**From:** [REDACTED]  
**To:** [Norfolk Vanguard](#)  
**Cc:** [Cawston PC](#)  
**Subject:** Cawston Parish Council - Deadline 8 submissions  
**Date:** 30 May 2019 21:02:33  
**Attachments:** [Cawston Parish Council response to Document Reference ExA Comments 10D7208 - Deadline 8 Submission.pdf](#)  
[Cawston Parish Council Submission for Deadline 8 - Updates on Traffic Incidents, Documents, Meetings and ExA questions.pdf](#)

## CAWSTON PARISH COUNCIL SUBMISSION FOR DEADLINE 8

DETAILS OF TRAFFIC INCIDENTS IN RECENT WEEKS, RESPONSES TO DOCUMENTS PUBLISHED FROM DEADLINE 7 AND THE EXA'S FURTHER QUESTIONS, WITH AN UPDATE FROM OUR MEETING WITH VATTENFALL ON 28TH MAY

Cawston Parish Council's response to Document Reference: ExA; Comments; 10.D7.208 Deadline 7  
*Alternative Construction Routes at Cawston, Applicant's Comments on Deadline 6 Written Submissions: Appendix 2*

### OPTION 1: PASSING PLACES

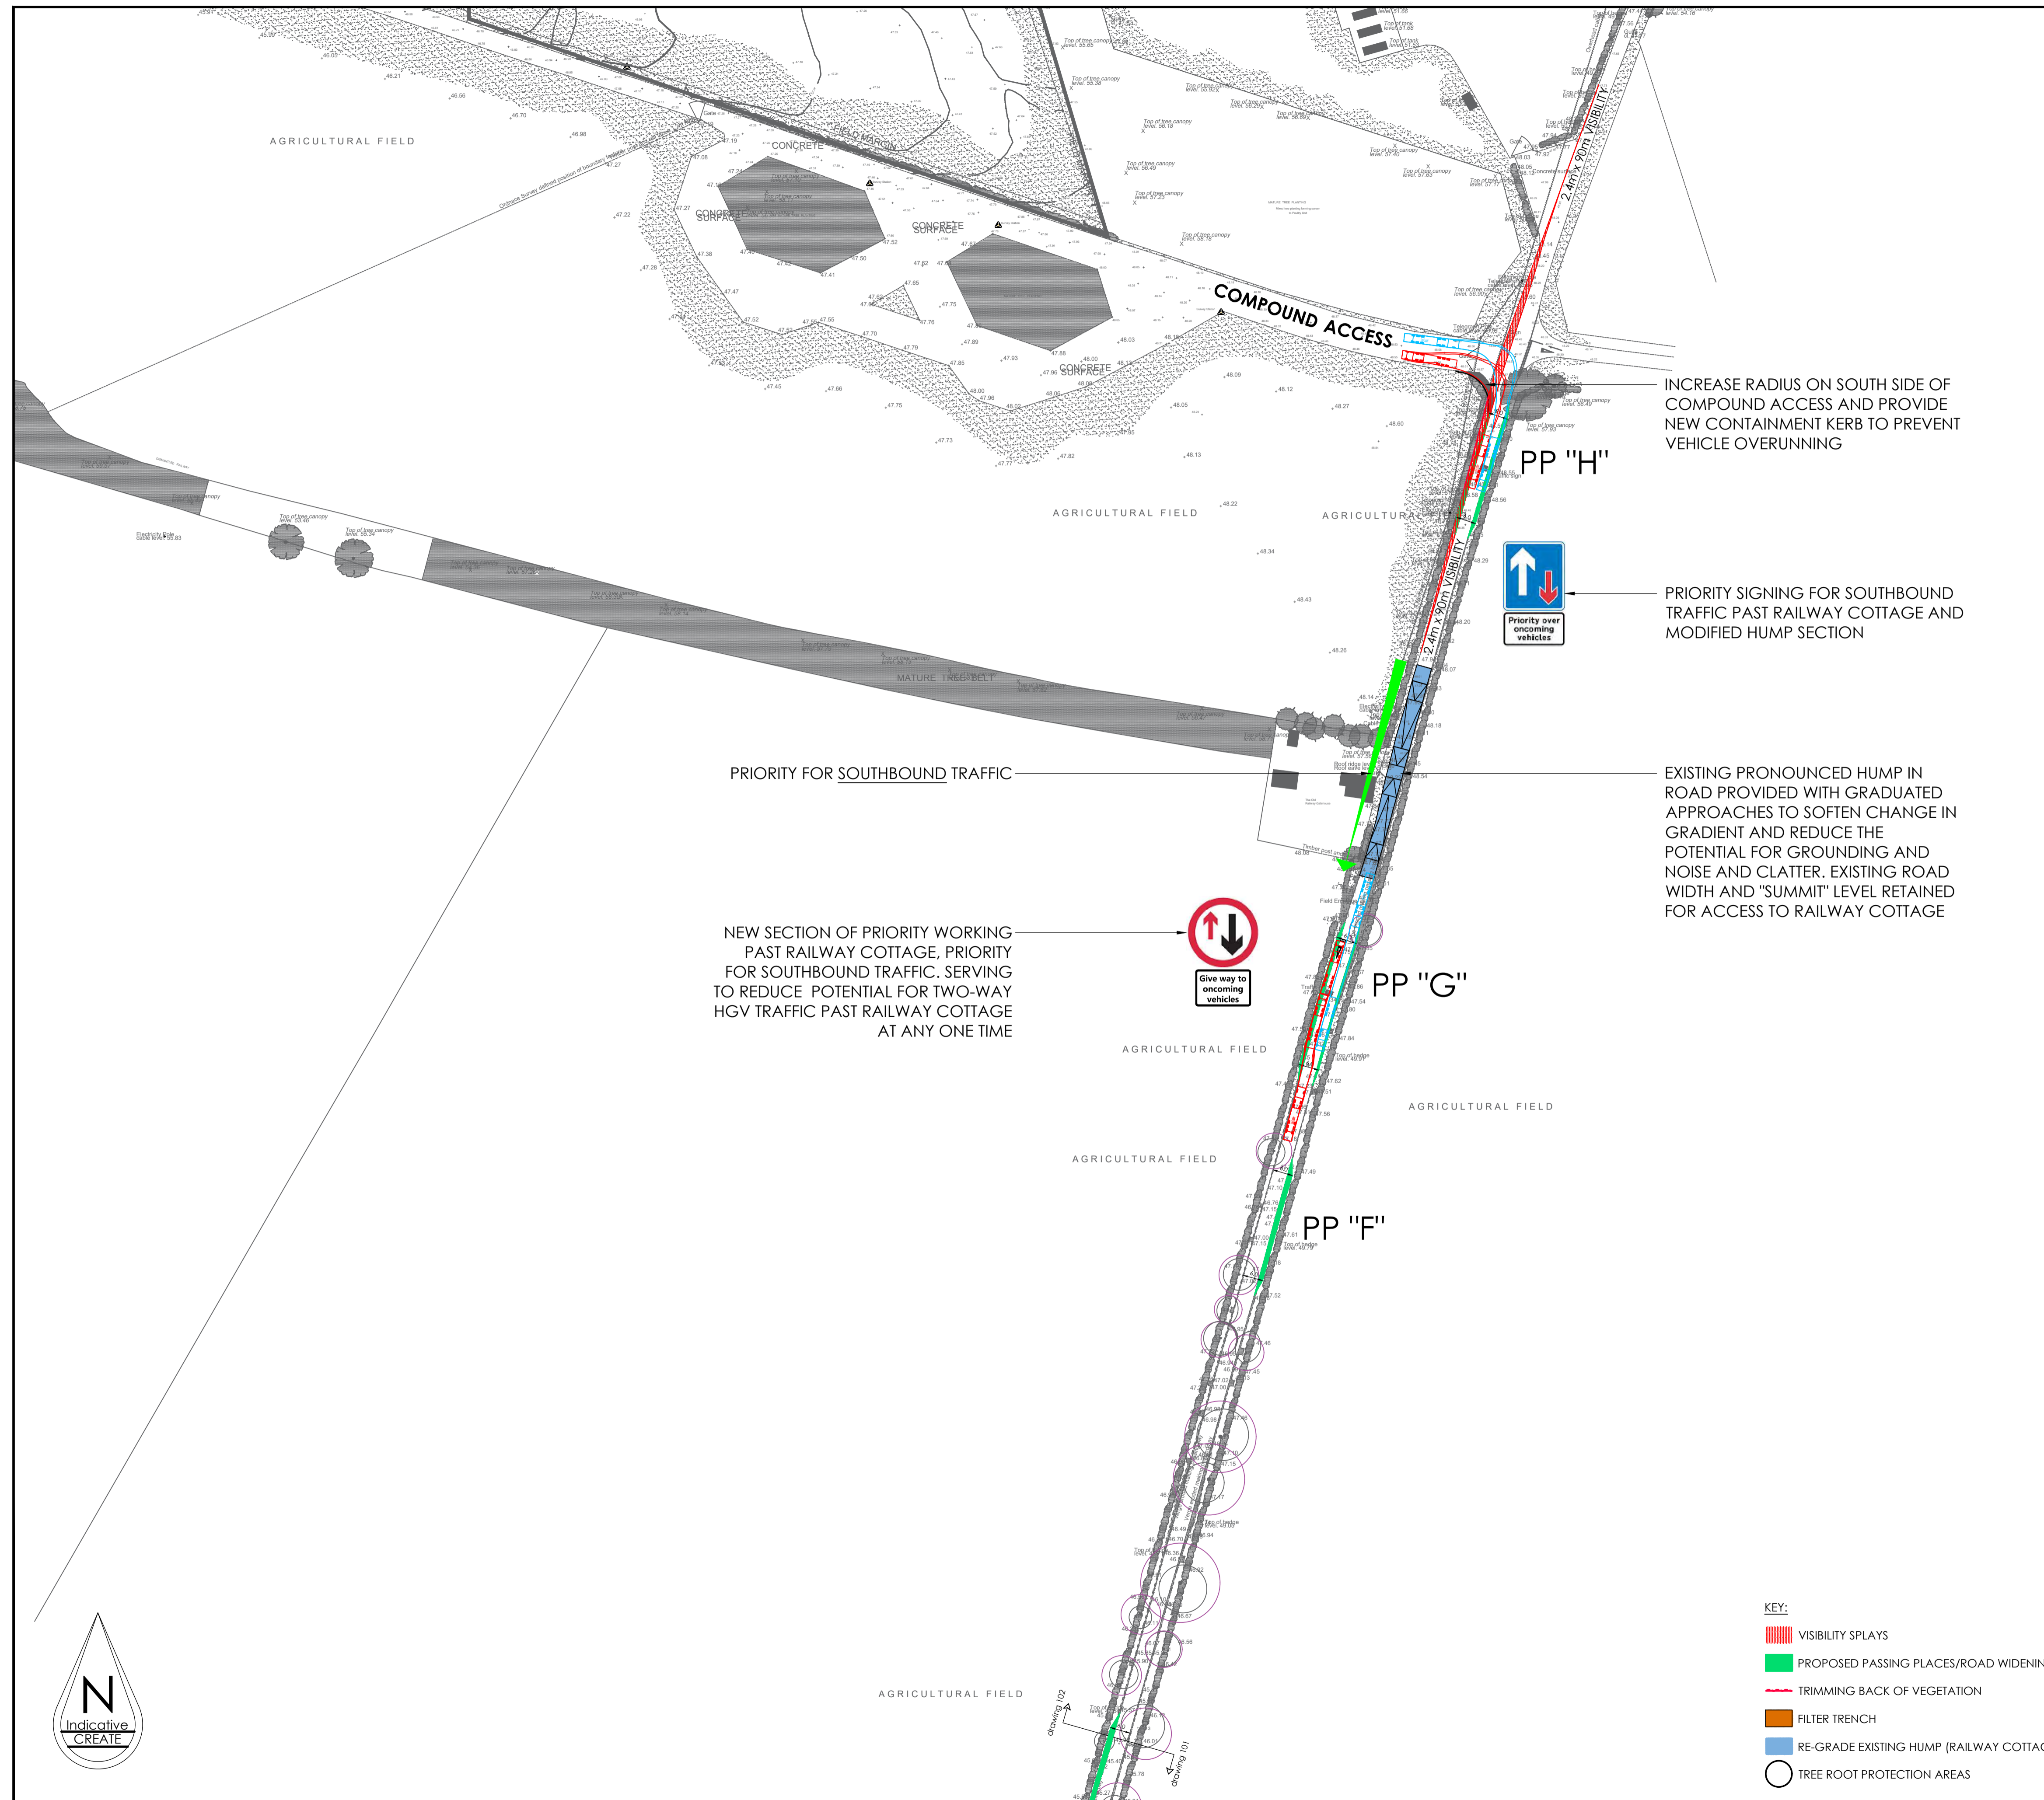
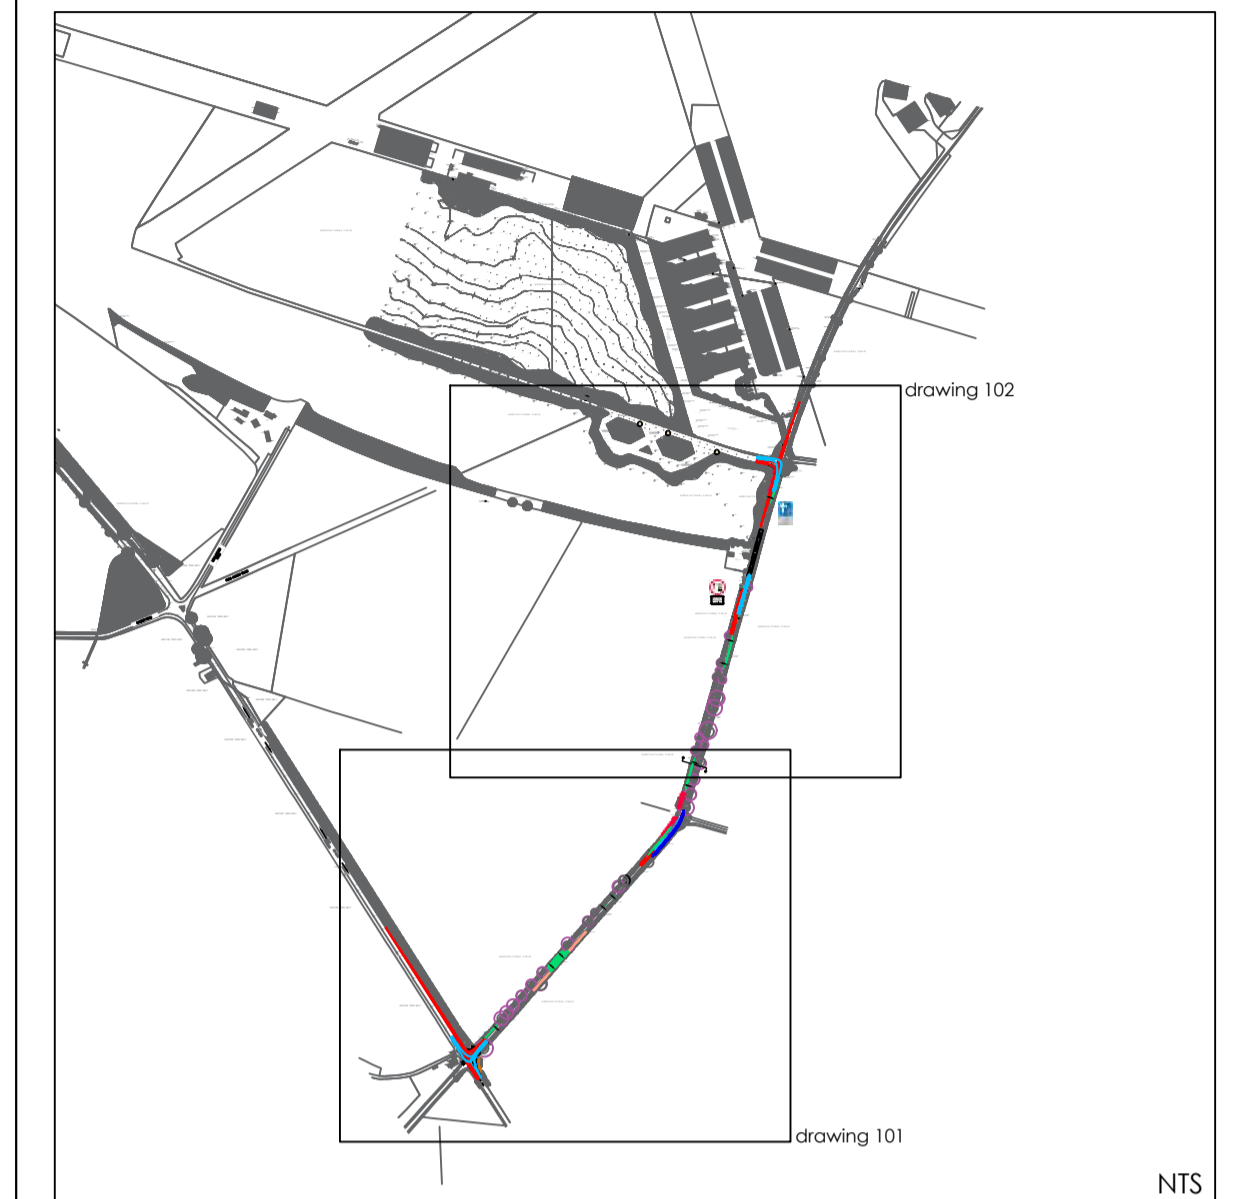
Road Safety measures include a 20mph limit for the whole of the village. HGV traffic travelling through Cawston at the moment regards 20mph as an aspirational target. A further road safety measure is the fantasy scheme of single way priority working, proposed for two locations on the High Street: one on the bend at the west end of the High Street, the other on the bend at the east end of the High Street by the Chapel Street junction. In both locations it is proposed to narrow the road so only a single vehicle can pass. Highway engineers seem to think this arrangement is workable. Others may question how drivers can see around a

corner before pulling into the single track section. This is even more of a problem if you are driving an HGV and you have a tail of following traffic which prevents you reversing.

If an HGV manages to enter the centre section of the High Street its driver must hope to encounter any oncoming traffic in the two small passing spaces created by parking restrictions. Anywhere else and reversing will be necessary. Cawston Parish Council's understanding of the current predicted peak HGV flow is that either 35 or 43 HGV movements through the village need to be completed in each hour. The impact of traffic on air quality, noise and vibration is the subject of ongoing discussions with the applicant and others.
